design statement

20 beverley drive

clitheroe

This design statement has been prepared to support a planning application for the alterations and extensions to :-
20 Beverley Drive, Clitheroe, BB7 1HY

first floor plan

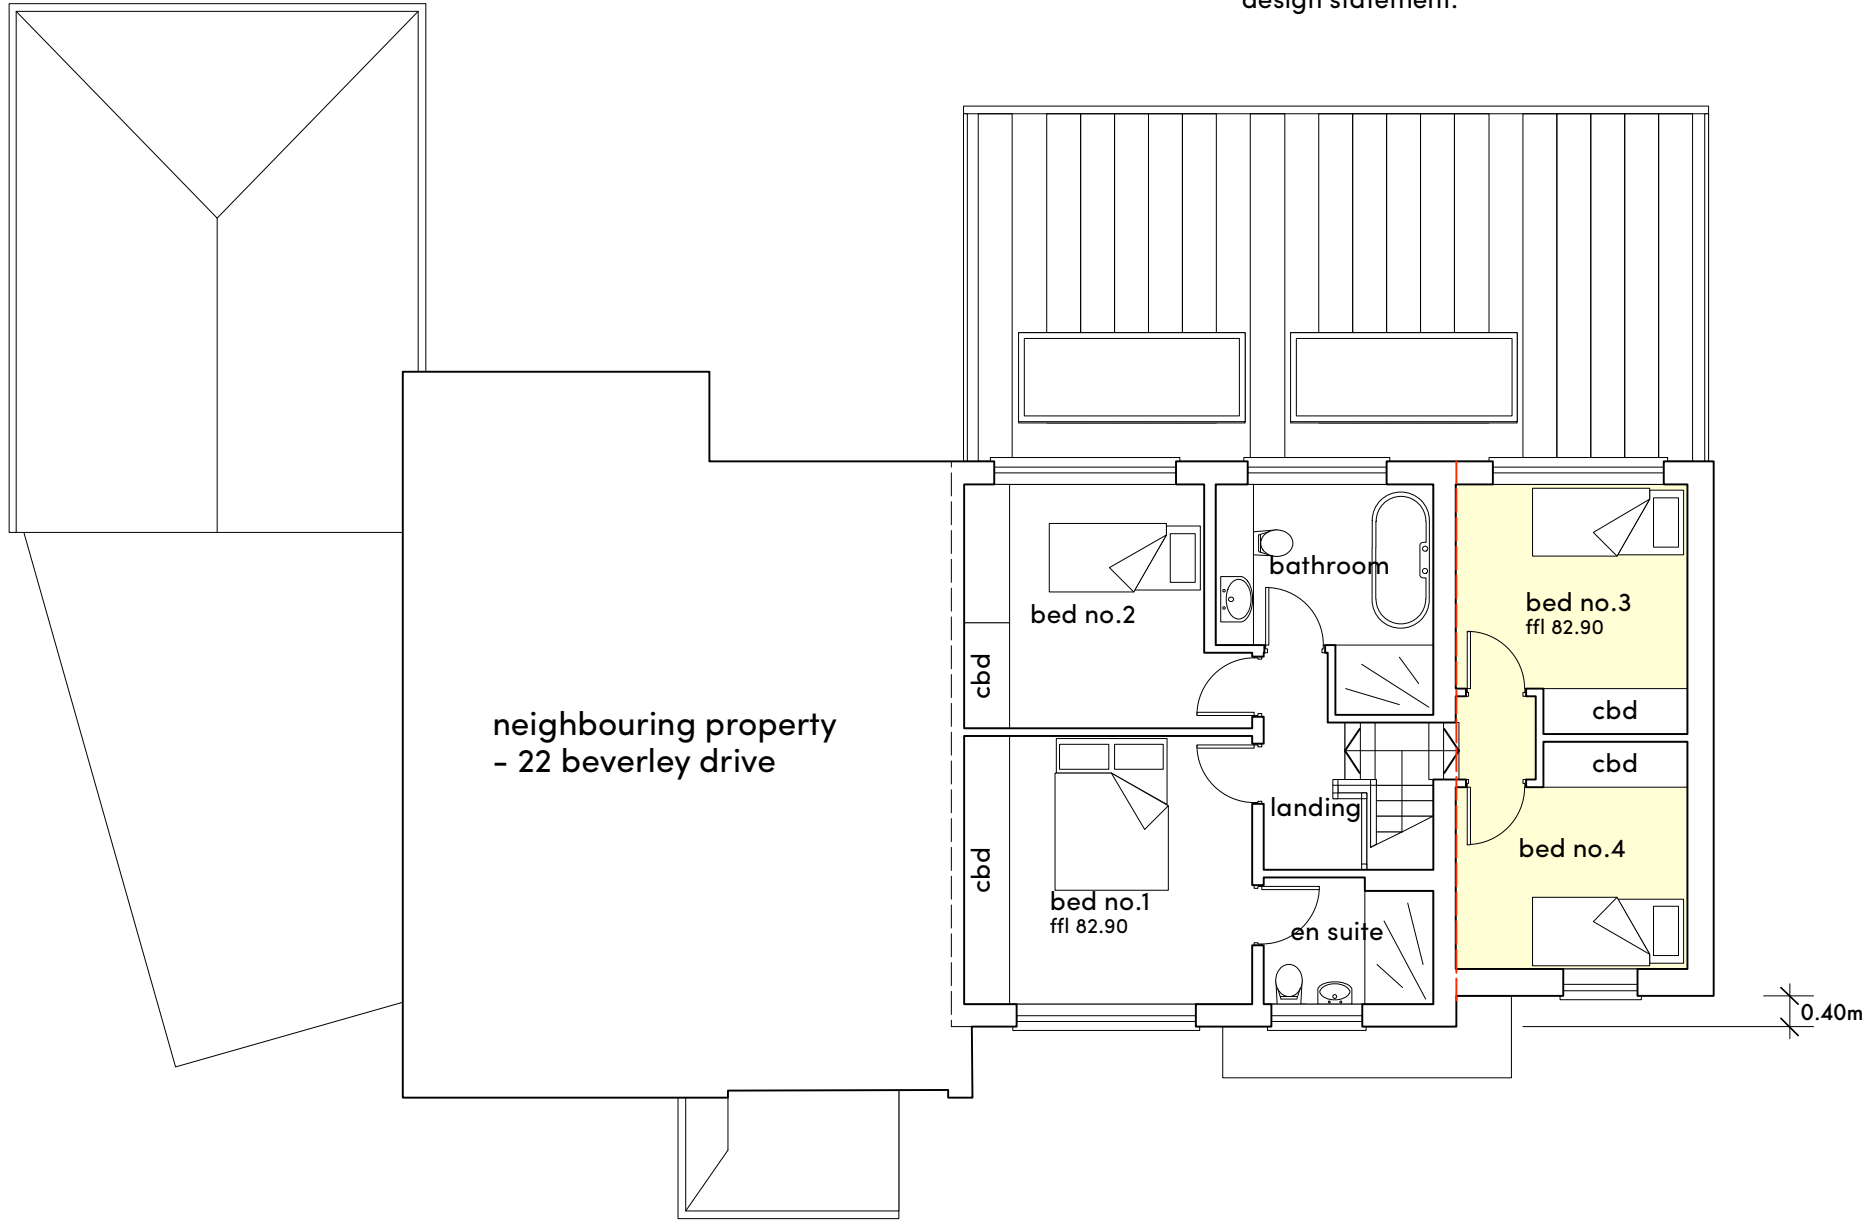
"It appears the proposed two storey element will come forward of the principal elevation of the existing garage structure. Given we typically request a 1m set back at first floor for two storey extensions, it would be advised to maintain the existing principal building line to ensure the extension remains subservient. The roof of the extension will sit below that of the ridge of the main dwelling, as per the submitted plans, this assists in the development taking a subservient position."

"Based on the submitted plans, the proposed scheme is considered broadly acceptable, subject to details of materials and a reasonable set back being provided for the two-storey extension."

As noted in section 3.5, part of the pre-app advice was to set back the two storey side extension in line with the face of the existing garage (i.e. circa 1.8m). This request appeared to be excessive given Beverley Drive has examples of varied property lines including two storey extensions/projections forward of principal elevations in some instances (images to left).

Responding to the advice, the side extension remains set back from the principal front elevation. The latest proposal contains the maximum possible set back to ensure the third/fourth bedrooms are evenly sized for the applicants twin boys. This is without fundamentally altering the existing stair/landing/first floor or extending to the rear - meaning the current layout avoids unnecessary alterations and is the most efficient use of space. The set back is deemed to be reasonable to provide a clear distinction between original and new elements and can be viewed more positively than local precedents.
